Acceptance of Applications Checklist

Rosefield Solar Farm Section 55 Acceptance of Applications Checklist

Section 55(2) Acceptance of applications				
1	Within 28 days (starting day after receipt) The Planning Inspectorate must decide whether or not to accept the application for examination.	Date received	28-day due date	Date of decision
		26 September 2025	24 October 2025	23 October 2025
Section 55(3) – the Planning Inspectorate may only accept an application if it concludes that:		Planning Inspectorate comments		
Section 55(3)(a) and s55(3)(c): It is an application for an order granting development consent				
2	In accordance with sections(s) 14 to 30 of the Planning Act 2008 (the PA2008), is the development a Nationally Significant Infrastructure Project (NSIP) (or does it form part of an NSIP); and does the application state on the face of it that, in accordance with s31 of the PA2008, it is an application for a development consent order (DCO) under the	Yes The proposed development set out in schedule 1 of the Draft DCO (Doc 3.1) includes development falling within the categories in s14 of the PA2008. The development is for the construction of an onshore generating station in

KEY:

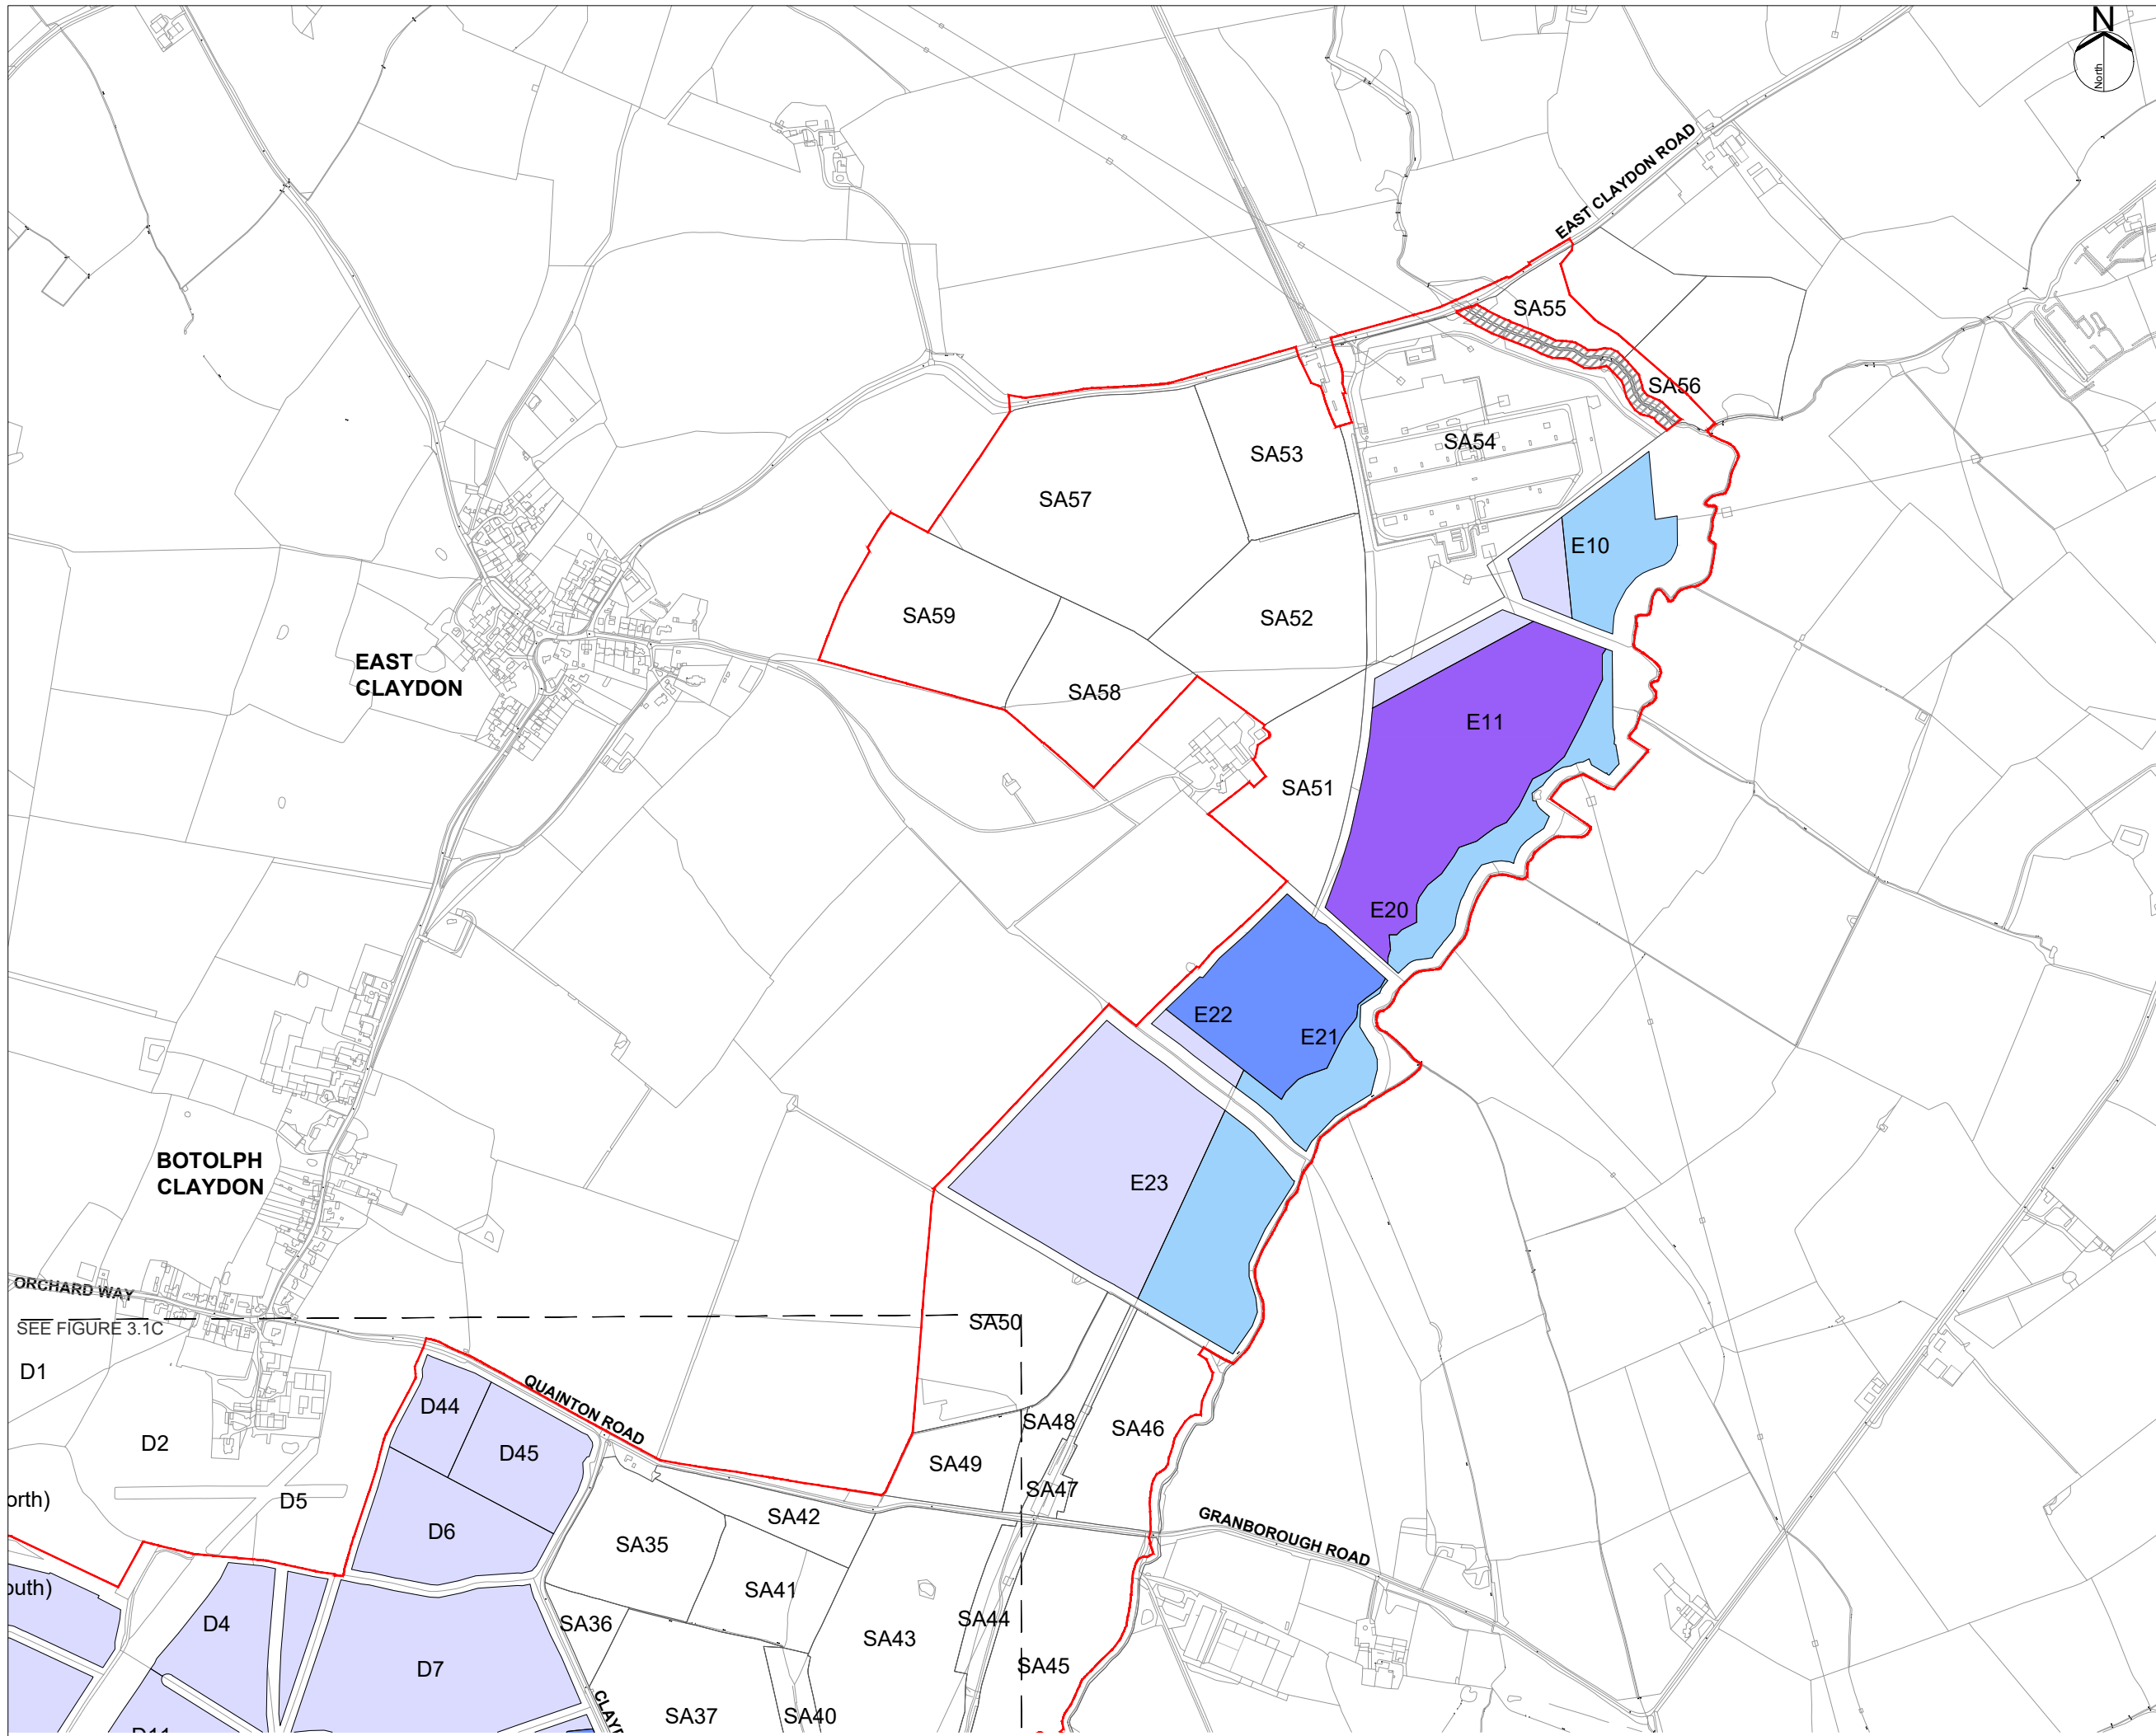
Revise shading to clearly distinguish between proposed development heights of up to 6m from those of up to 15m.
